LAND USE CONSULTANTS
Design · Planning ·
Management
3605 Colby Ave – Everett, WA 98201

RE: 1st Review Responses
Linscott-Kirk SP (SP23006)

Planning Comments:

PRELIMINARY SHORT PLAT MAP  
 FOR  
**LINSCOTT - KIRK SP**  
 IN THE SE 1/4 OF THE SE 1/4 OF SECTION 16, TWP.30 N., R.5 E., W.M.  
 CITY OF MARYSVILLE, SNOHOMISH COUNTY, WASHINGTON

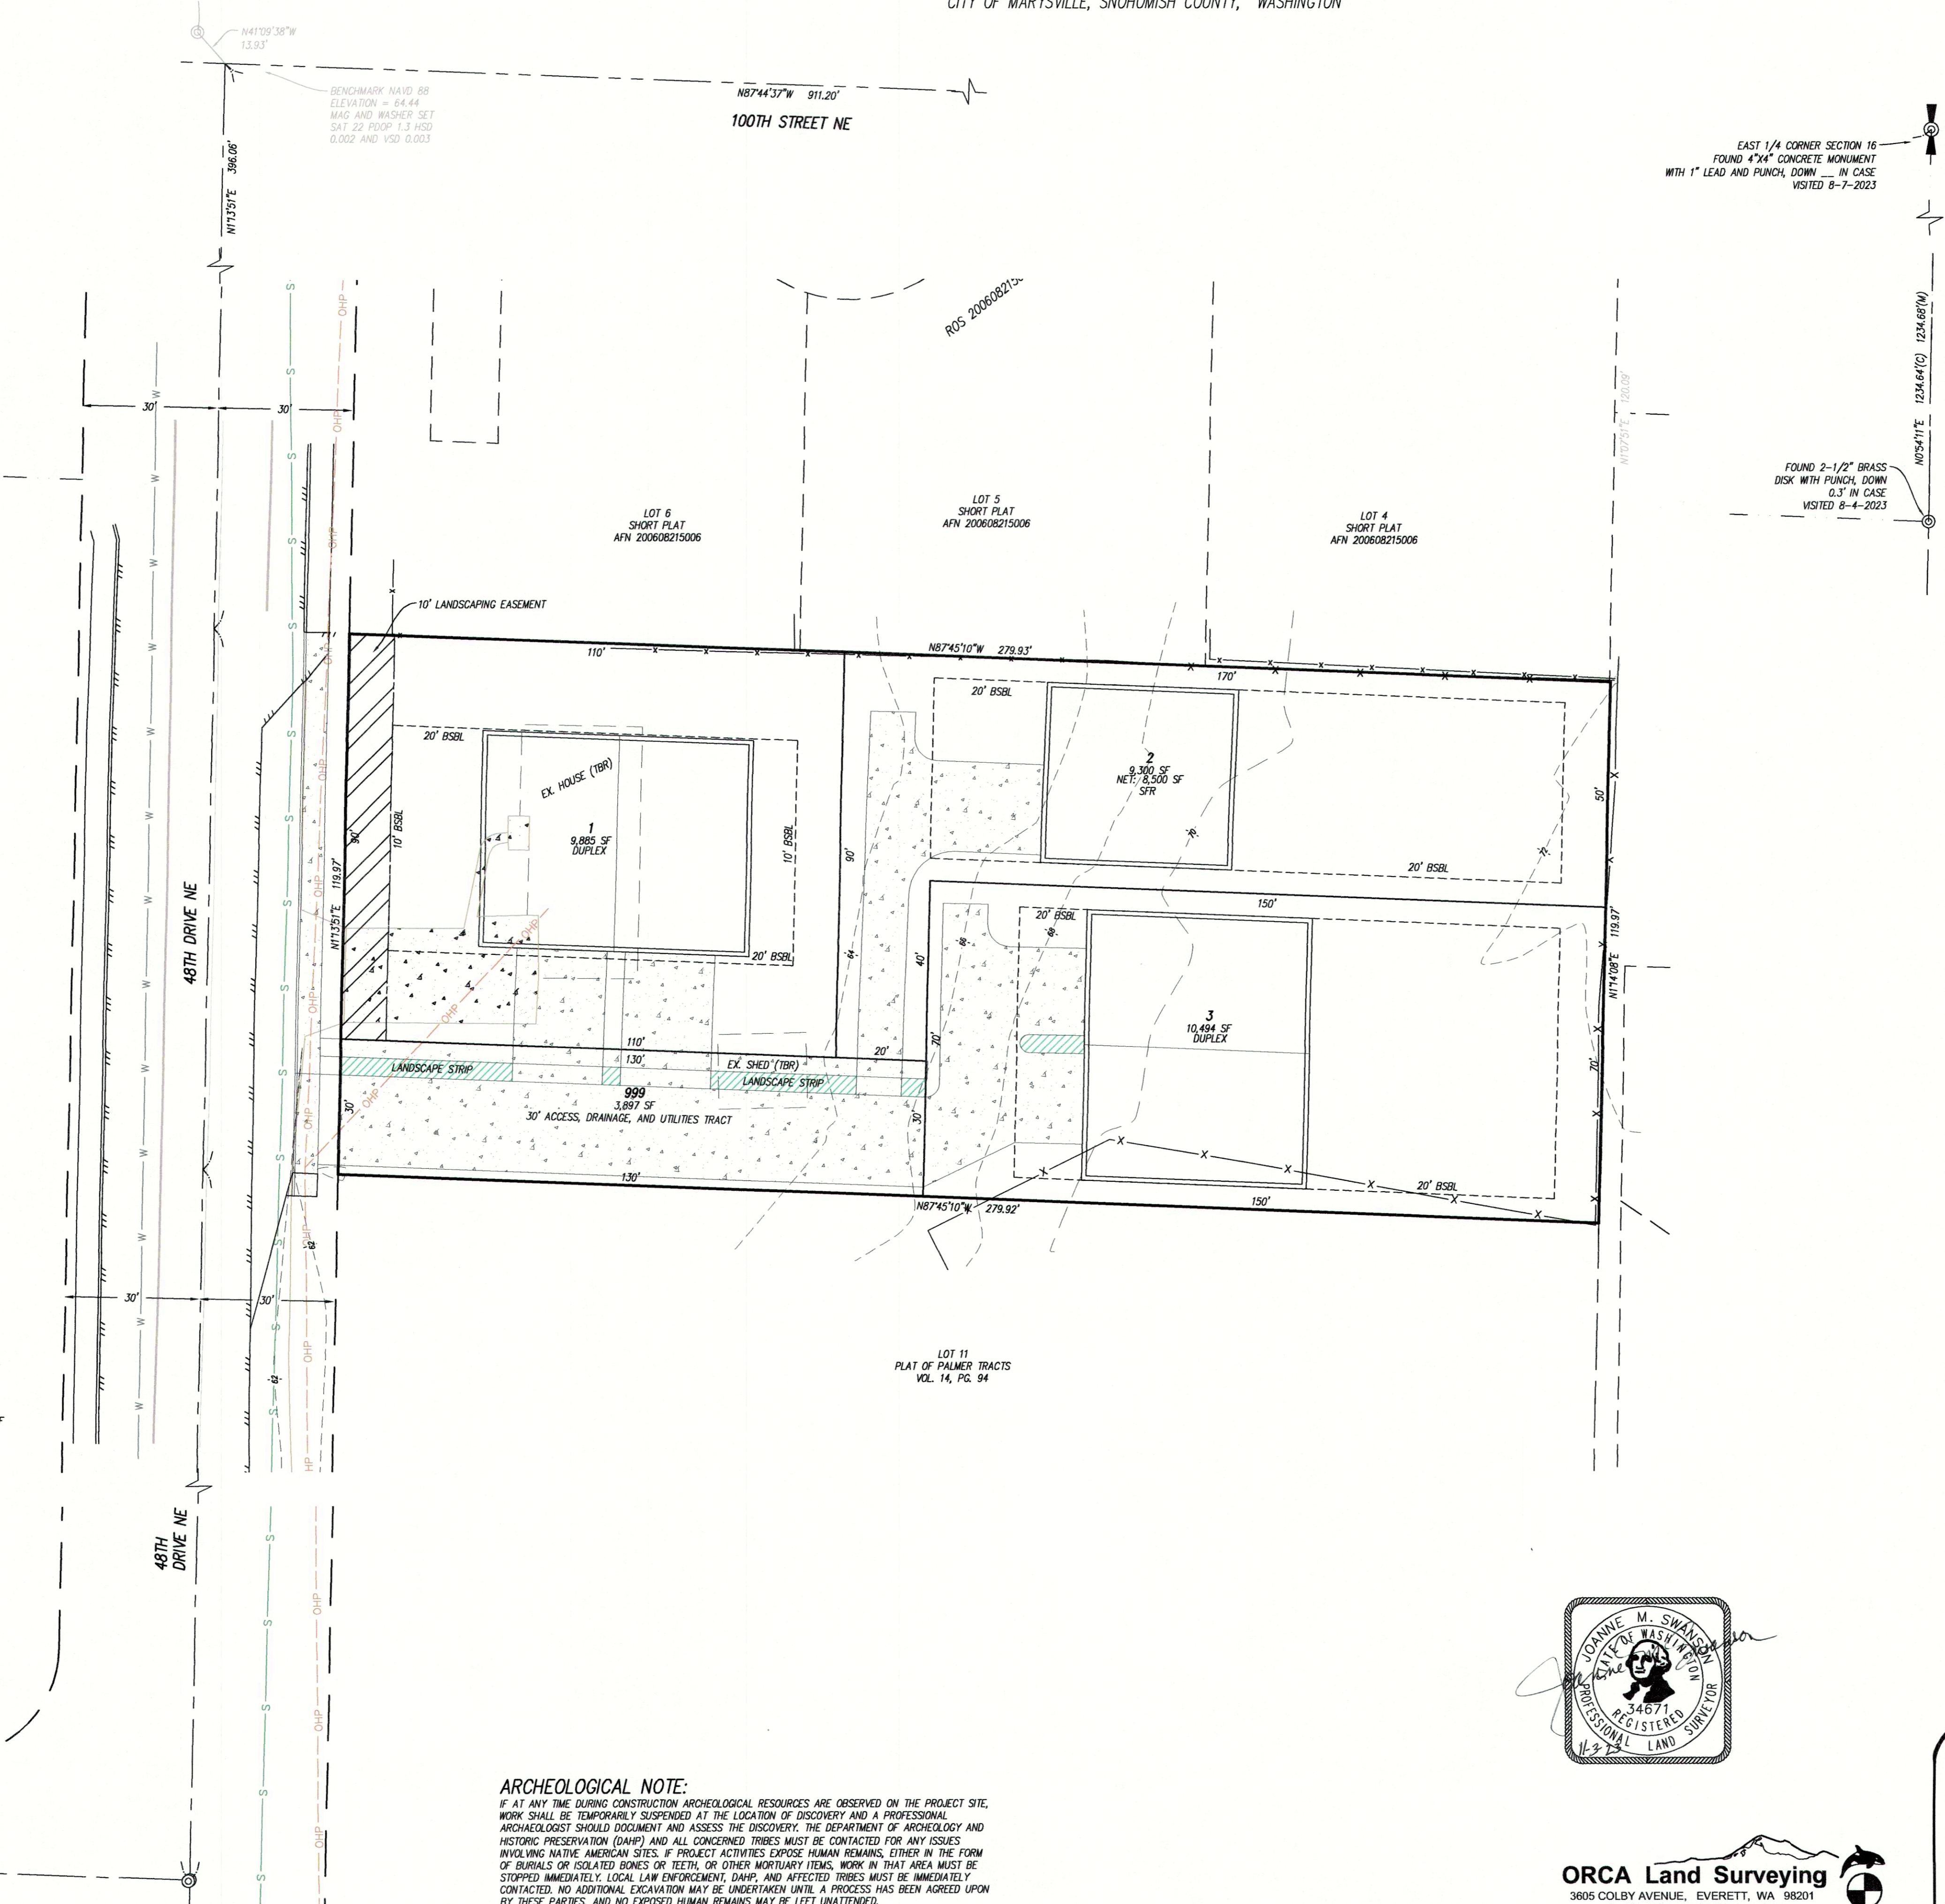
1. Include File Number SP23-006 on all future correspondence, in addition to all site, civil and landscape plans. – *Added.*
2. Per MMC 22C.010.290(2), sites shall be oriented to create an attractive street edge and are to have primary entrances facing the street. Additionally, street facing residences would be consistent with the character of the neighborhood. As proposed, Lot 1 would not meet the intent of this section. Staff does note that the comments from the pre-application mentioned that if units along 48th Dr NE are not oriented towards the street, then a 10 ft. landscape easement would be allowed. However, this is not an allowable or desired deviation to the above code section. Revise site plan to remove the proposed landscape easement and orient the lots to have the primary entrances facing 48th Dr NE with garage access in the rear. – *After speaking with Mr. Rob Linscott regarding the Linscott-Kirk SP, we were informed the driveway access is fine to remain as is so your planning comment #2 no longer applies. As such, the only revisions needed were to the landscape plan. Because Mr. Linscott and yourself discussed the architectural elements of the duplex footprint to make an attractive streetscape, we adjusted the duplex footprint on the landscape plans accordingly.*
